**Town of Addison**  
**Summary of Engineering Review Comments**

Date: December 5, 2019  
 Plan Review : Civil Review 2  
 Received: November 13, 2019  
 Plan Date: November 11, 2019  
 Development: Galaxy FBO

Town Project #:19-09D

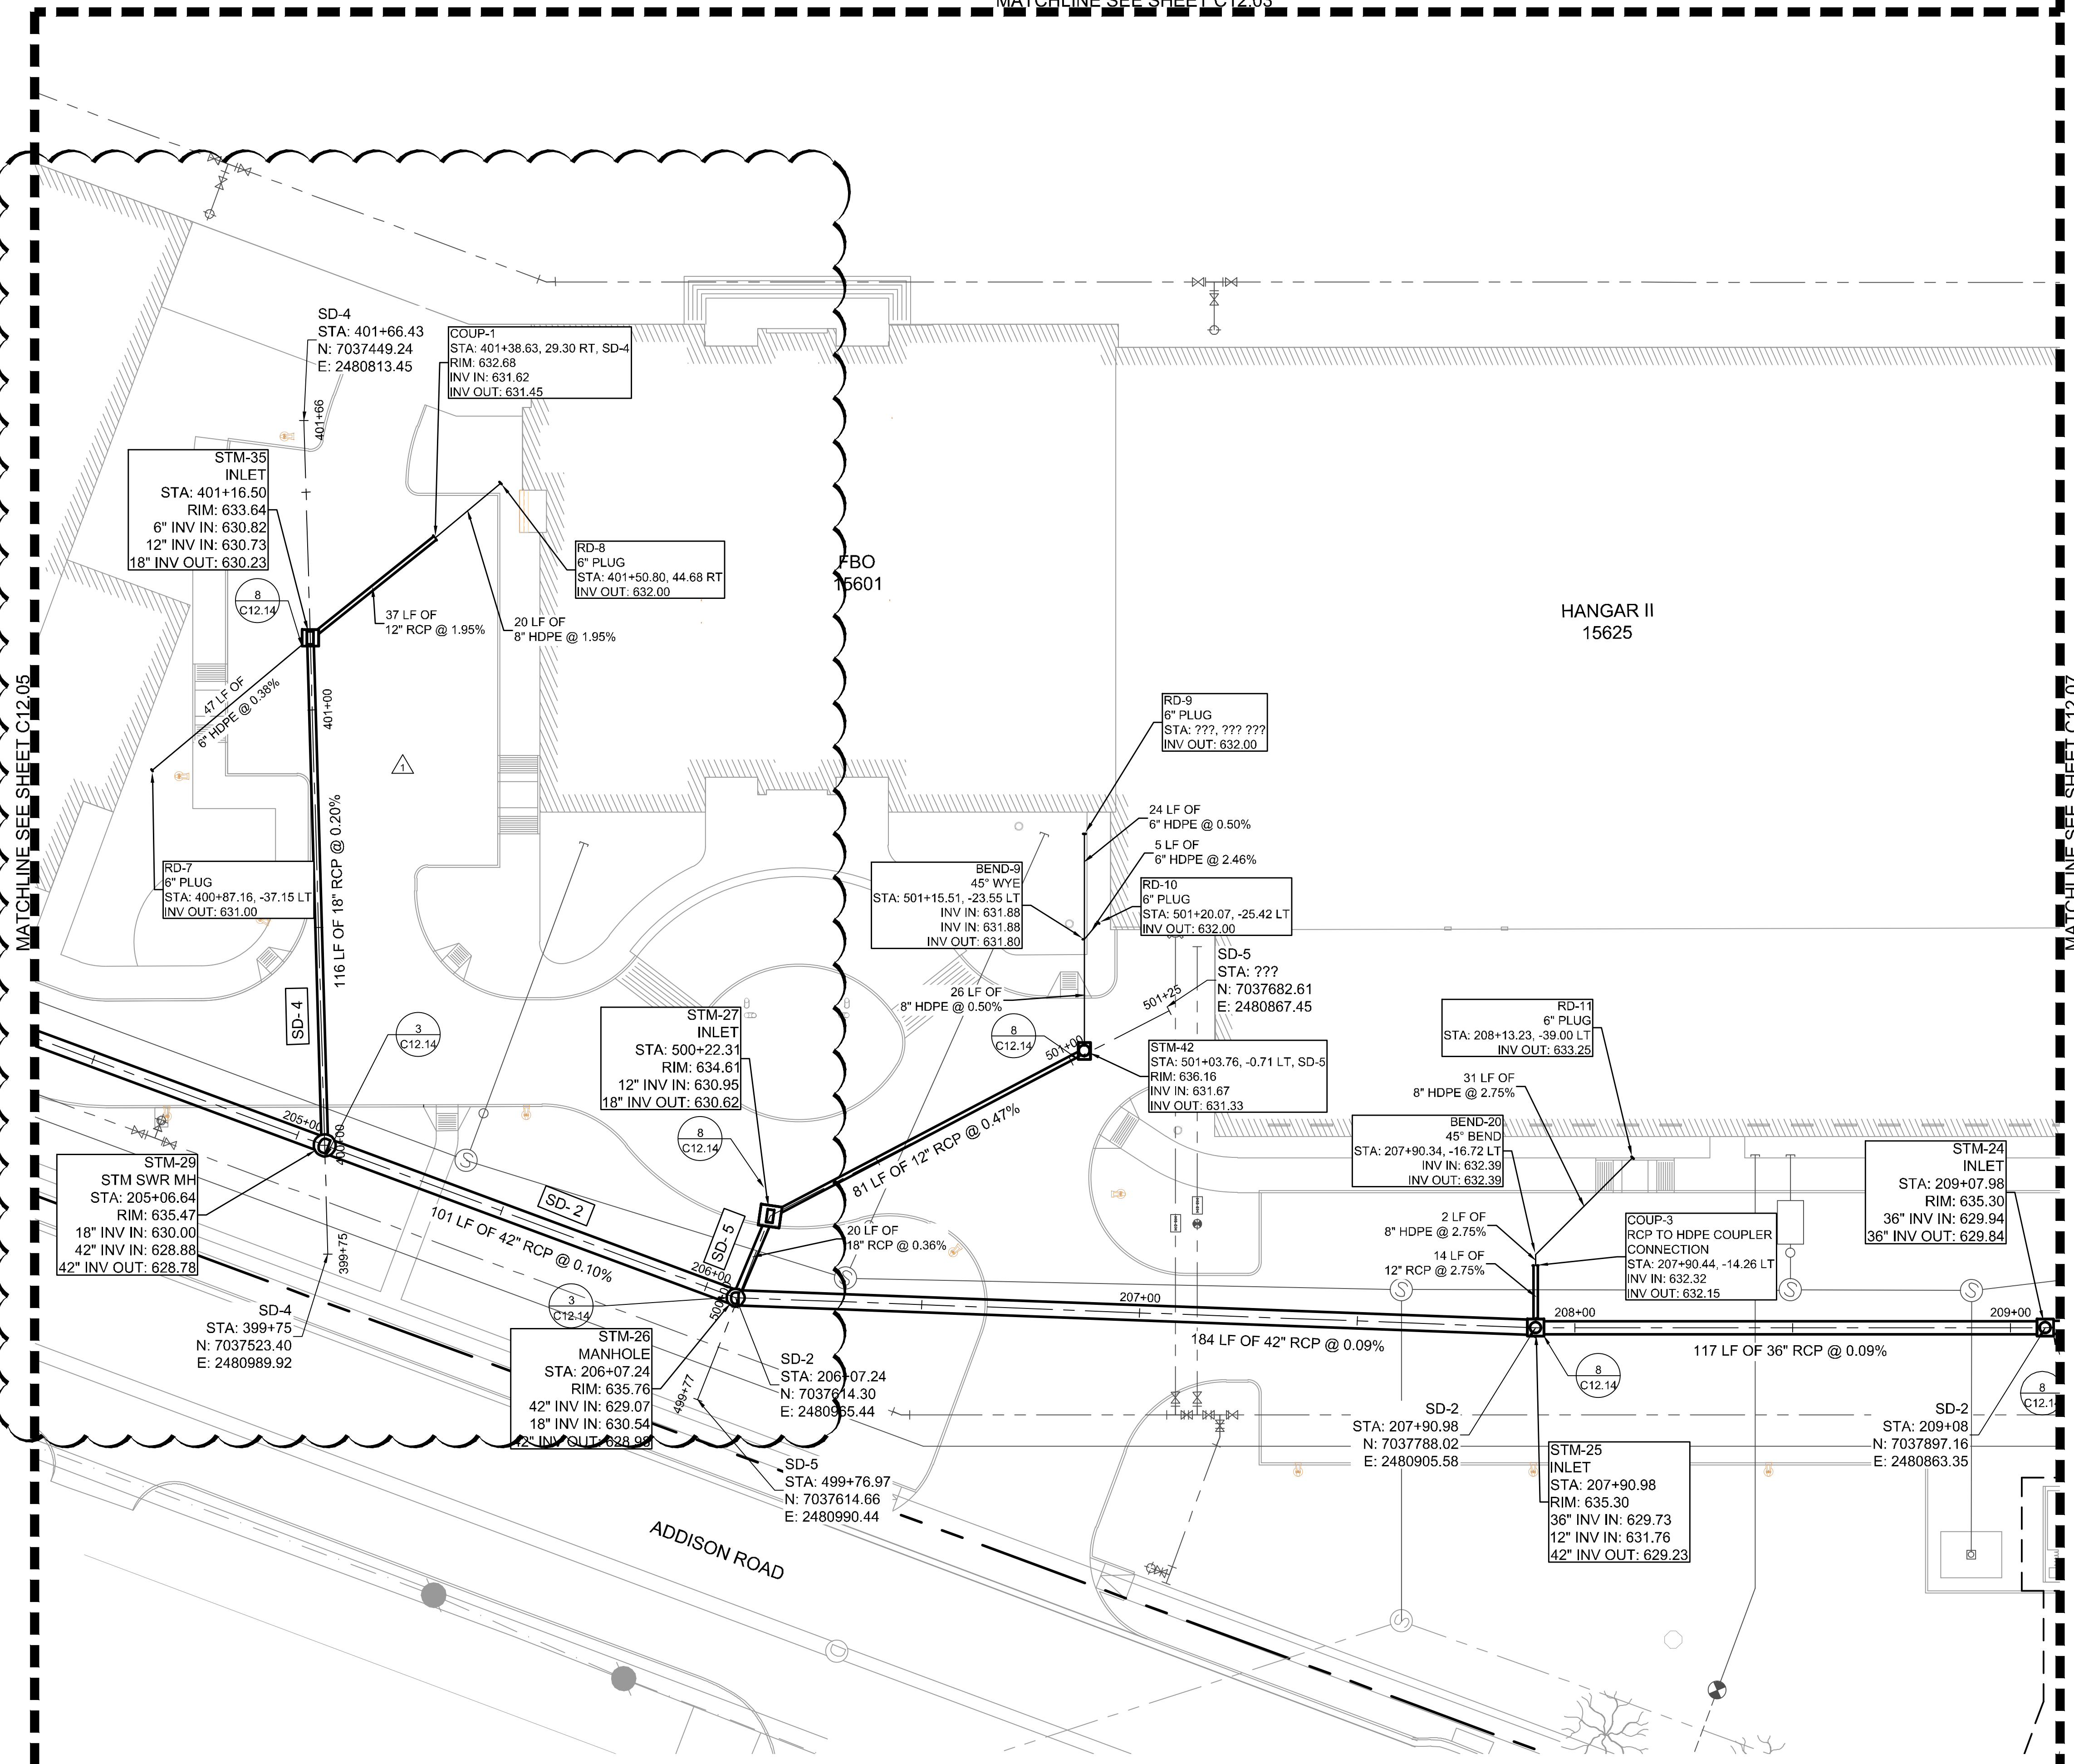
Page No.	Comments	Response (See Note)	Explanation
C12.06 & C12.08	SD-5 alignment should follow the full length of the line & structures should be stationed off the SD-5 alignment, not SD-2. Include all pipe segments & structures in profile.	AGREE	THE SD-5 ALIGNMENT HAS BEEN UPDATED TO FOLLOW THE FULL LENGTH ON THE STORM DRAIN LINE AND THE STRUCTURES HAVE BEEN STATIONED OFF OF THE SD-5 ALIGNMENT. ALL PIPE SEGMENTS HAVE BEEN ADDED TO THE PROFILE ON SHEET C12.08.
C12.07	Identify & profile storm drain connecting to ex fuel farm drainage (SD-7?)	AGREE	THE STORM DRAIN CONNECTING TO THE FUEL FARM HAS BEEN IDENTIFIED AS SD-7 AND THE PROFILE HAS BEEN ADDED TO SHEET C12.08.
C12.08	Call out pipe sizes of the inverts (like in plan view)	AGREE	PIPE SIZES ARE NOW INCLUDED IN THE INVERT CALLOUTS ON SHEET C12.08.
C12.08	Show all utility service crossings.	AGREE	ALL UTILITY CROSSINGS ARE SHOWN ON SHEETS C12.08 AND C12.09.
